Rezoning Transportation Analysis

Petition Number: #2022-086

From: Jake Carpenter, PE

Date	Description
11-28-22	First Review (TM)

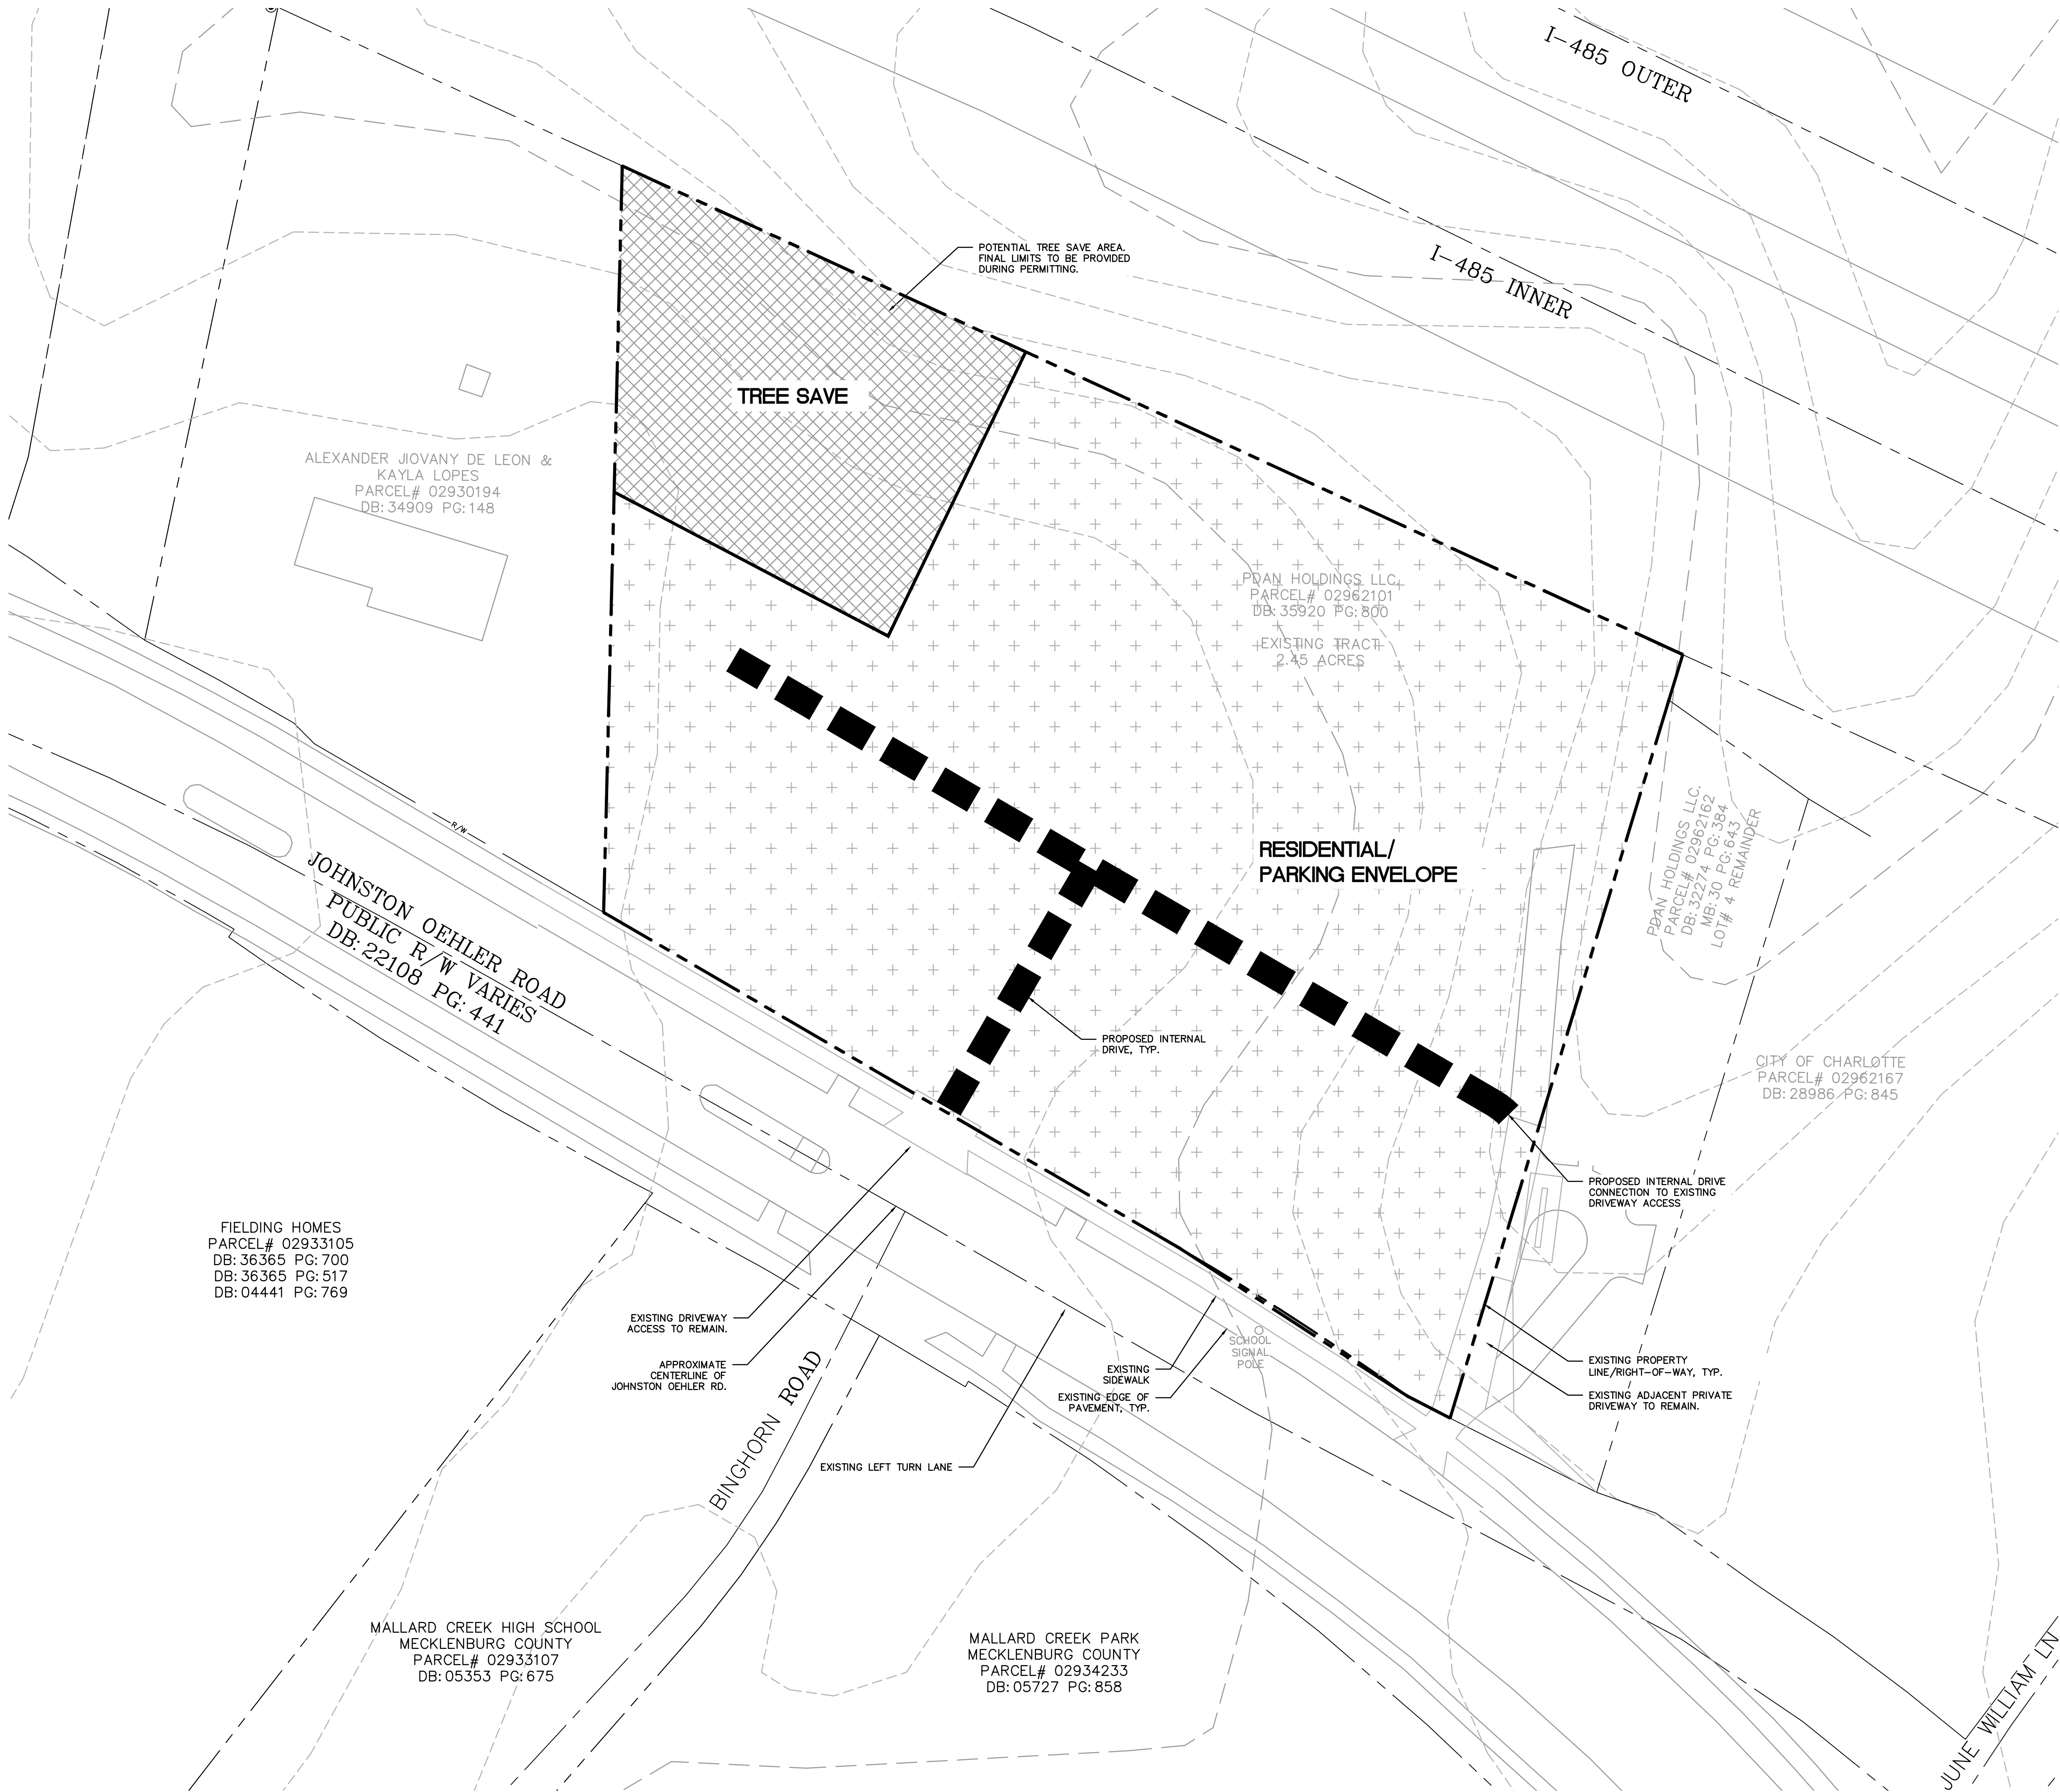
4. Revise site plan and conditional note(s) to relocate site access to the west side of the property to the west of the existing pedestrian refuge. Revise callout that states the existing driveway is to remain to say that the existing driveway is to be closed. If proposed driveway cannot be relocated west of existing median, the existing median will be required to be removed to provide a left turn lane. In this access scenario, a potential pedestrian hybrid beacon proposed at this location will be required to be maintained or will be required to be installed if not constructed by the time of permitting. Document these conditions within the conditional notes.

5. Revise site plan and conditional note(s) to commit to construct an 8-foot planting strip, and 6-foot sidewalk along Johnston Oehler Road Chapter 19. The site plan shall label and dimension both items from the back of curb and gutter and road centerline.
